**Approval of details reserved by condition imposed under P/25/17/OUT relating to conditions 4-
Construction Phasing Scheme, 5-Materials Schedule, 9-Arboreal Method Statement, 15-
Ecological Management and Mitigation Plan, 20-Employment and Skills Plan, 22-Renewable Energy,
23-Broadband Provision and 26-Electrical Vehicle Charging.**

Church Barton House Horns Lane Pagham PO21 4NZ

Condition Number 4

Arun District Council have decided to **REFUSE details reserved by condition for the following reasons:**

SITE LAYOUT
SCALE - 1:500

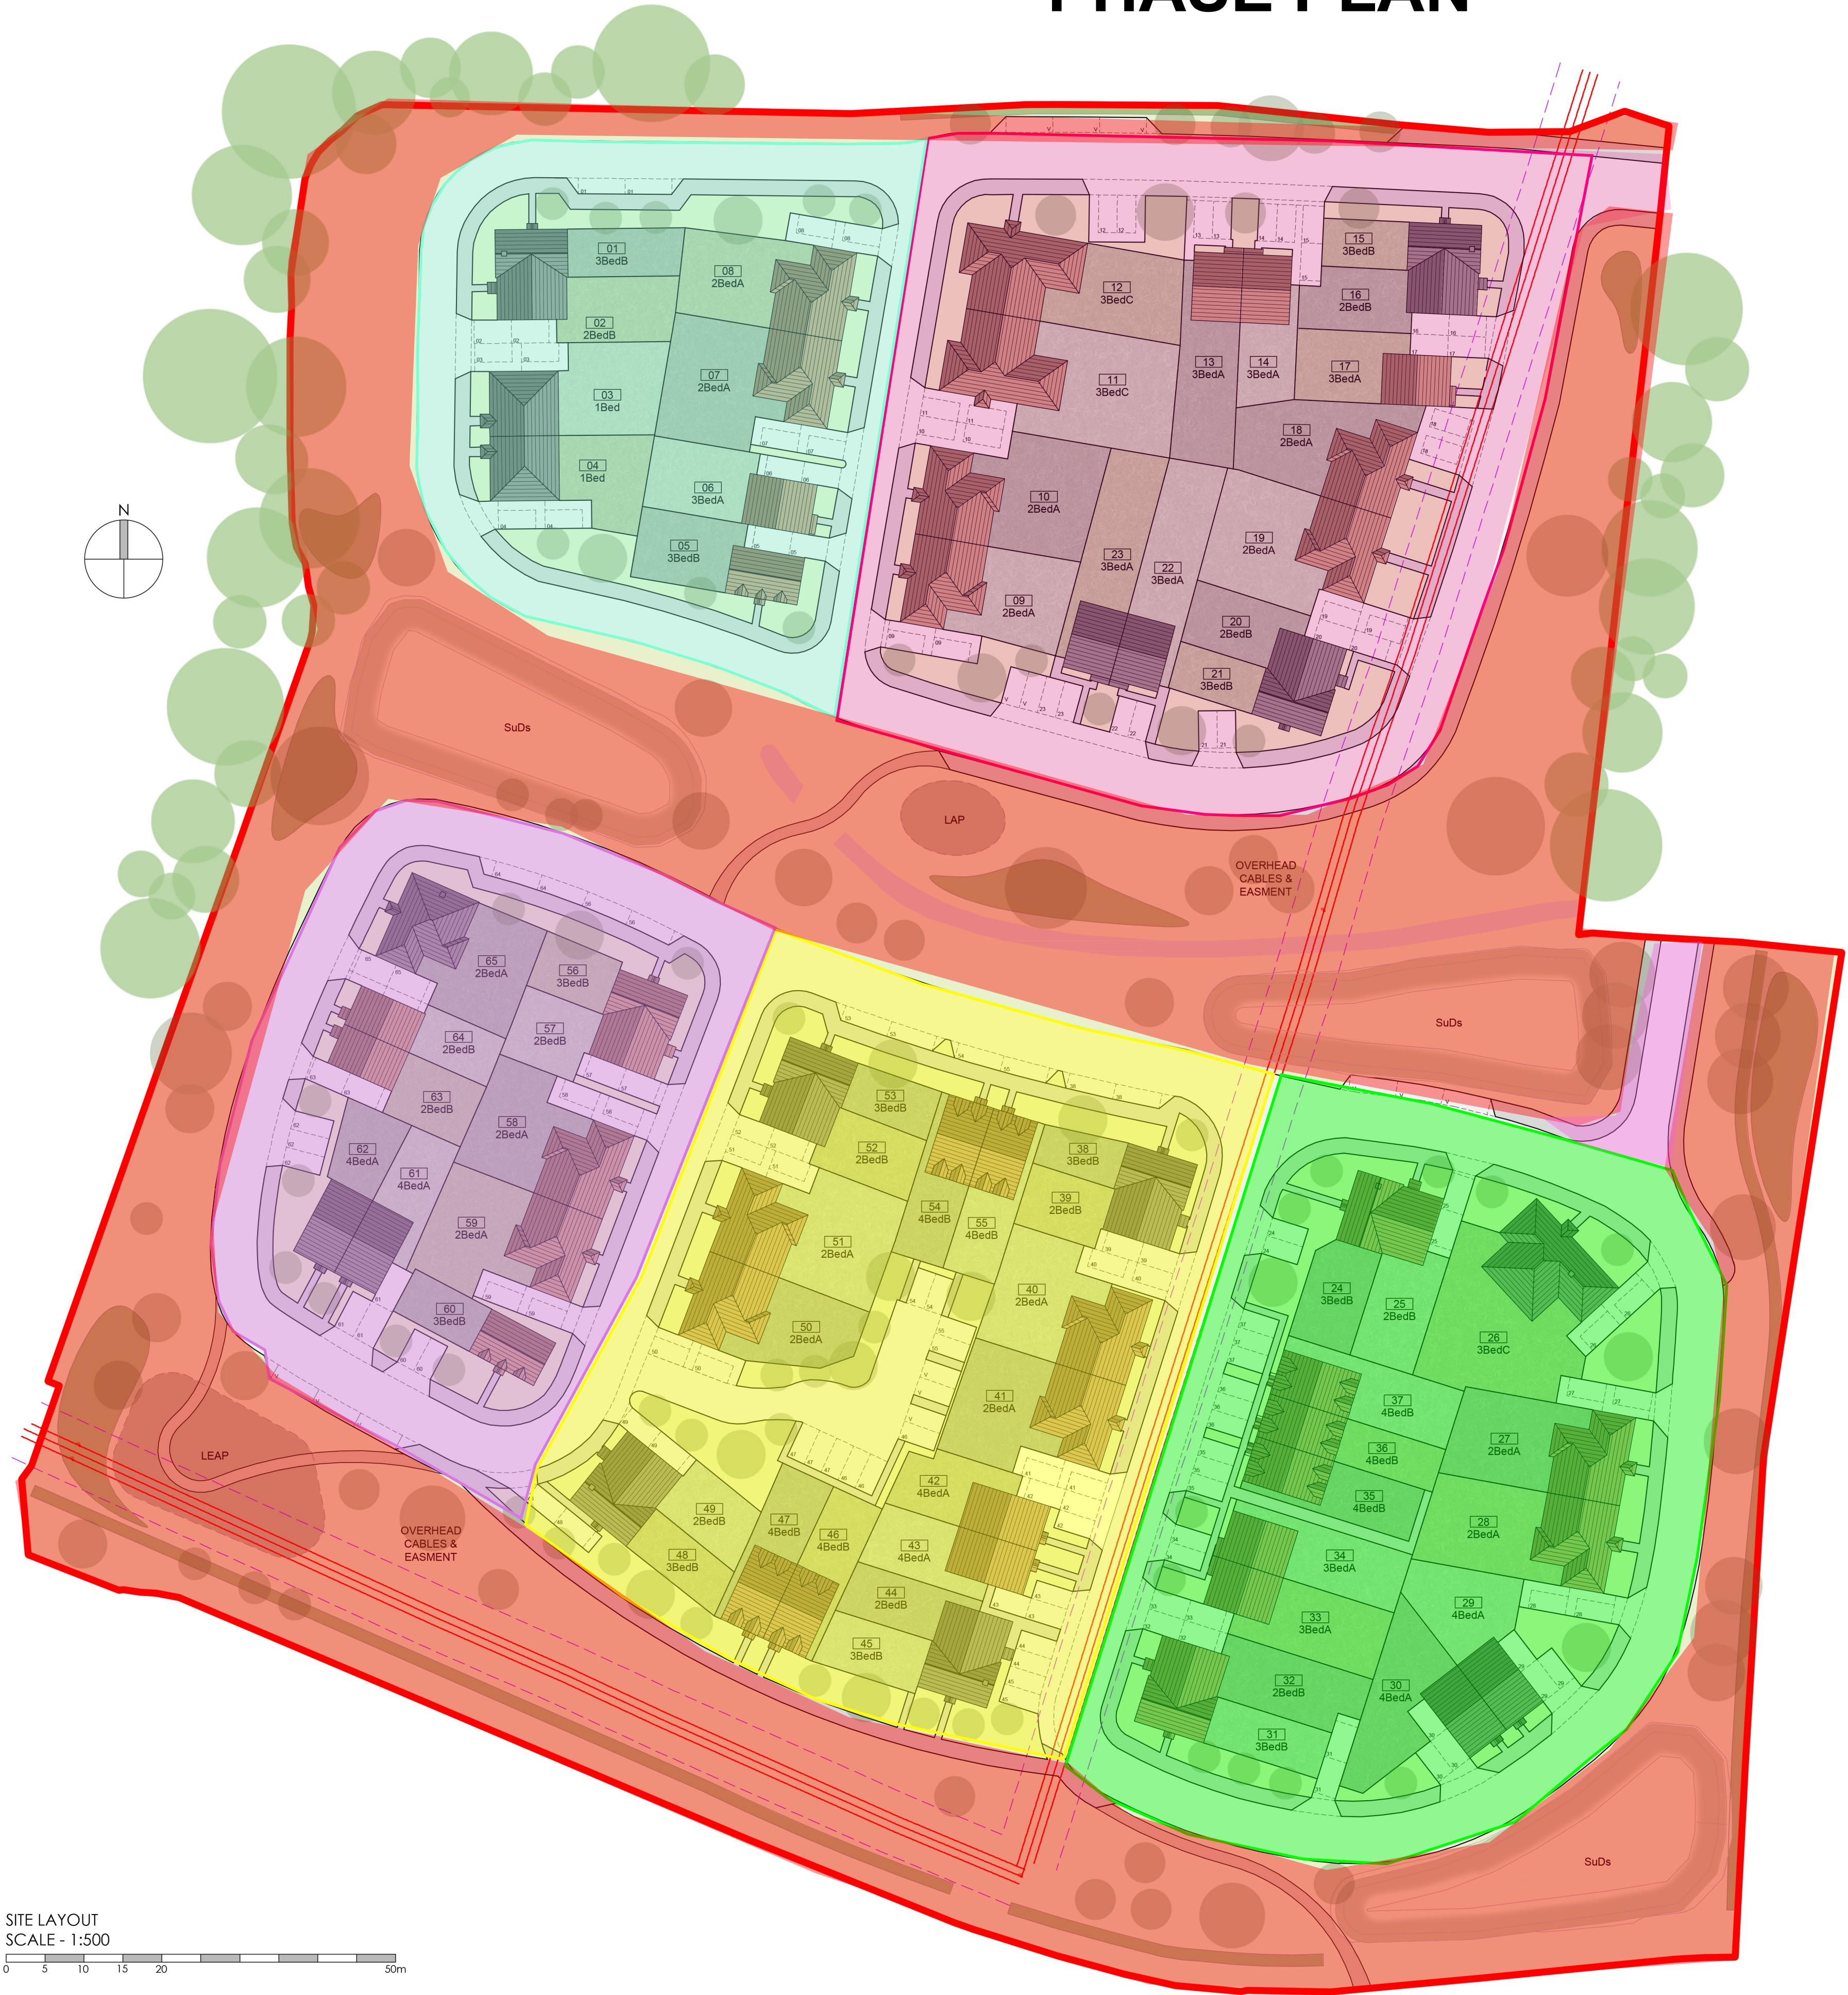
The applicant has submitted a Phasing Plan which seeks to discharge Condition 4. The phasing plan shows that all Public Open Space (POS) will be delivered at the end of the development, in its own separate phase.

The Phasing Plan delivers all open space at the end of the development whereby residents could be occupying dwellings much earlier than when any footpaths and landscaping are provided.

The Council have not undertaken an Appropriate Assessment in order to assess the proposals in details against the HRA requirements, however it is unlikely to be able to successfully pass the AA process at this time.

As such, the application is refused and the condition is not discharged.
